Application no: **3/2021/1009**

Address: **10 Southern Close Longridge PR3 3FS**

Proposal: **Demolition of detached garage and construction of two-storey and single-storey extensions to side and porch to front.**

The Local Highway Authority have viewed the plans and highway related documents and have the following comments to make:

Proposed Site Plan 1:200

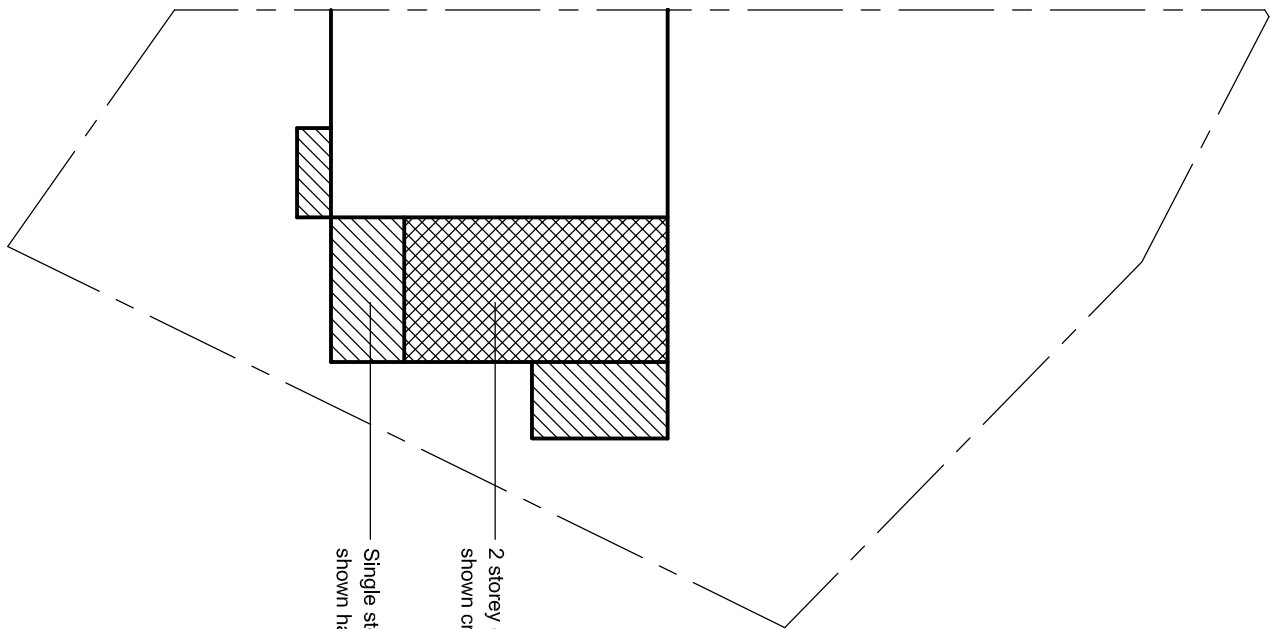
The LHA have reviewed David Haworth drawing number 1447/01 Rev B titled "Proposed Extension" and understands that 2 car parking spaces will be provided for

the 4-bed dwelling. These spaces will be provided on the driveway and in the single garage, which now complies with the dimensions found in the Joint Lancashire Structure Plan.

While the LHA are aware that the site does not fully comply with the parking guidance found in the Joint Lancashire Structure, with a 4-bed dwelling required to provide 3 car parking spaces, the LHA will accept the shortfall in parking at the site. This is because the LHA will be unlikely to advise refusal based on a shortfall of one car parking space given the existing situation and so the LHA have no objection to the proposal.

1. The development hereby permitted shall not be occupied until such time as the parking and turning facilities have been implemented in accordance David Haworth drawing number 1447/01 Rev B. Thereafter the onsite parking provision shall be so maintained in perpetuity.
